Ribble Valley Borough Council  
Church Walk,  
Clitheroe,  
BB7 2RA

Phone: 0300 123 6780  
Email: [lhscustomerservice@lancashire.gov.uk](mailto:lhscustomerservice@lancashire.gov.uk)  
Your ref:  
Our ref: LHS/CS/3/2016/0204  
Date: 14<sup>th</sup> April 2016

<b>Proposal:</b>	Extension of curtilage, new access onto Kiln Lane (Settle Lane), single storey extension to NW elevation (front) and single storey replacement conservatory to SE elevation (rear).
<b>Location:</b>	Buck House Settle Lane Paythorne BB7 4JD
<b>Grid Ref:</b>	382798 - 451979

Location Plan 1/1250

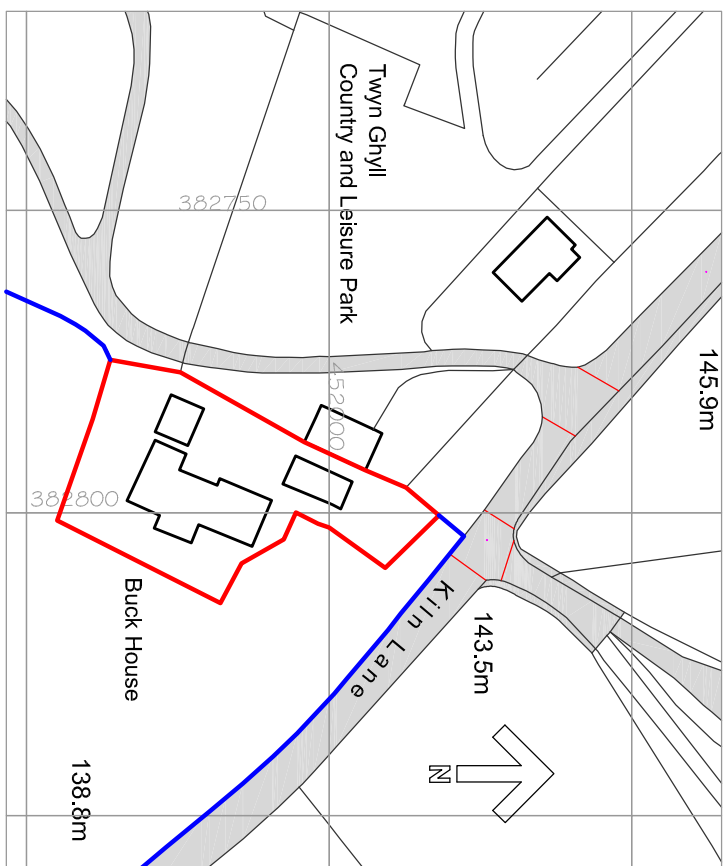
The Highway Development Control Section does not have any objections in principle to the proposed new access, providing the sight lines to the south west are protected under condition and the existing fencing is removed.

The shown sight lines of 2.0 x 70m to be provided in both directions from the centre of the new site access onto Kiln Lane.

From observations on site and the information provided on the applicant's site location plan the sight line requirement is fully achievable over the applicants land and the existing adopted highway. The main issue is the removal of the existing fence lines within the shown sightlines.

3. No part of the development shall be commenced until the visibility splays measuring 2.4 metres by 70 metres in both directions to be provided, measured along the centre line of the proposed new road from the continuation of the nearer edge of the existing carriageway of Kiln Lane, to the satisfaction of the Local Planning Authority. The land within these splays shall be maintained thereafter, free from obstructions such as walls, fences, trees, hedges, shrubs, ground growth or other structures within the splays in excess of 1.0 metre in height above the height at the centre line of the adjacent carriageway.  
Reason: To ensure adequate visibility at the street junction or site access in the interest of highway safety in accordance with Quality of Development Policy and Transport Policy in the Local Plan.
